**From:** planning  
**Subject:** FW: 3/2017/0862 - Millstone House, West Bradford - consultation response

**From:** Andrew Glover [<mailto:andy.glover24@hotmail.co.uk>]  
**Sent:** 02 October 2017 21:27  
**To:** planning  
**Subject:** 3/2017/0862 - Millstone House, West Bradford - consultation response

**Drawing Title:** Proposed Electrically Operated Gate

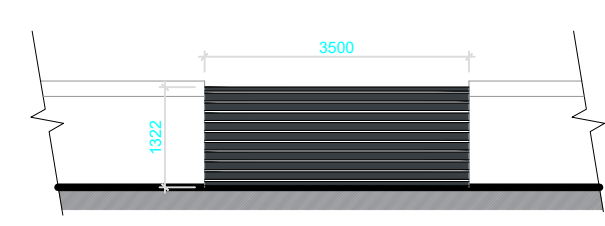
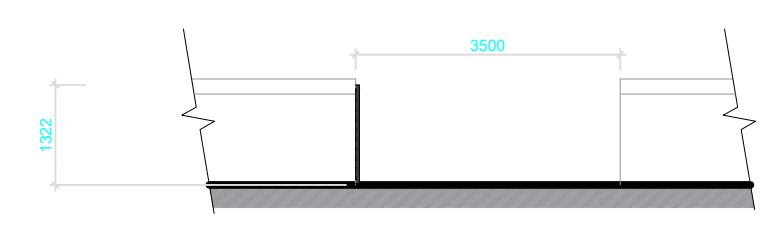
The Parish Council considered this matter at its meeting on 27 Sept 2017. The Parish Council felt unable to come to any definitive conclusions about the nature of the gates which were the subject of the application, feeling that there was very little detail given in either the plans or application form. Given that the proposed gates were located directly opposite to another residence, this was unfortunate. Whilst the Parish Council has no particular reason to be concerned about the proposal, it was felt that the inclusion of more descriptive text to illustrate the proposed gates would have assisted its discussions.
